Two storey extension, single storey rear extension and external staircase.
Mews House London Road Arundel

Thank you for your internet representation made on 13th March 2019 which has been recorded as '**an objection**' with the comments as follows:

Application ref: AB/14/19/HH

MPS		PROPOSED ELEVATIONS AND SECTIONS	14/01/19	A
DRAWN	CHECKED		DATE	REV

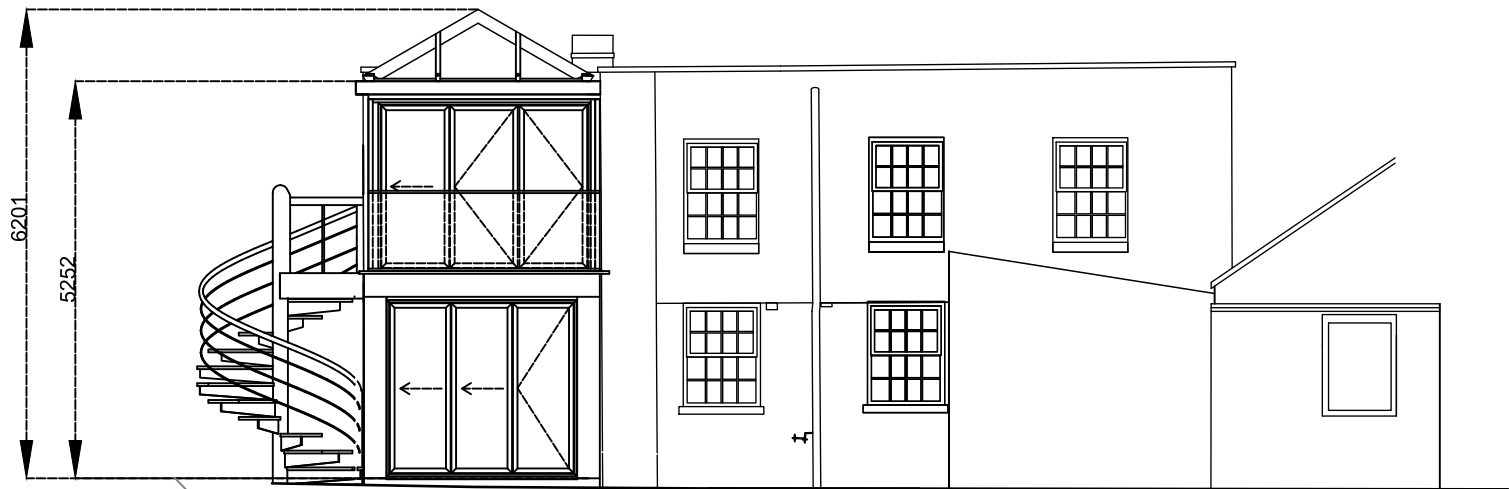
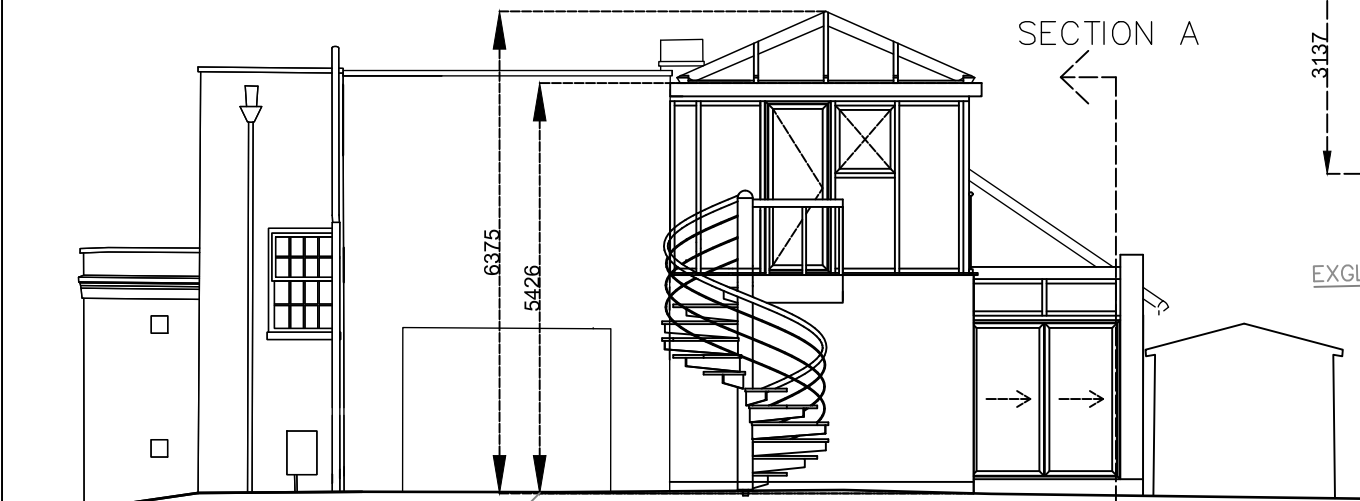
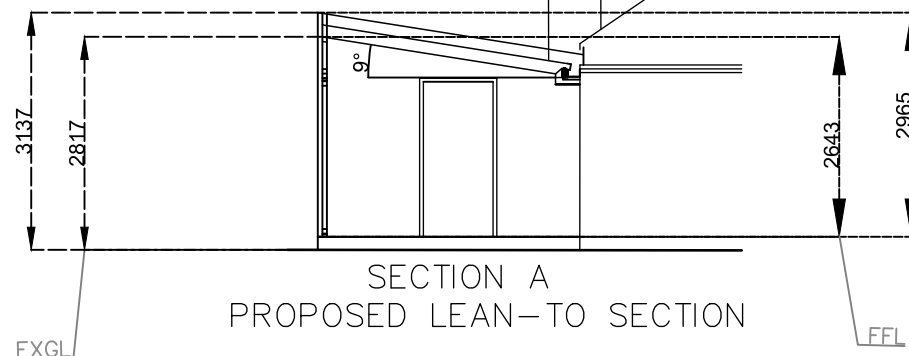
The proposal, because of its siting, scale and height would affect adversely the visual amenities of the area. The proposed extension is on the southwest corner of the house and the front west side of the sunroom, with its door and prominent external staircase, would inevitably be clearly visible from London Road. While I appreciate that conservatories are permitted development at ground level, this proposal constitutes a conservatory at FIRST floor level which would be an inappropriate and dominant feature in a Conservation area.
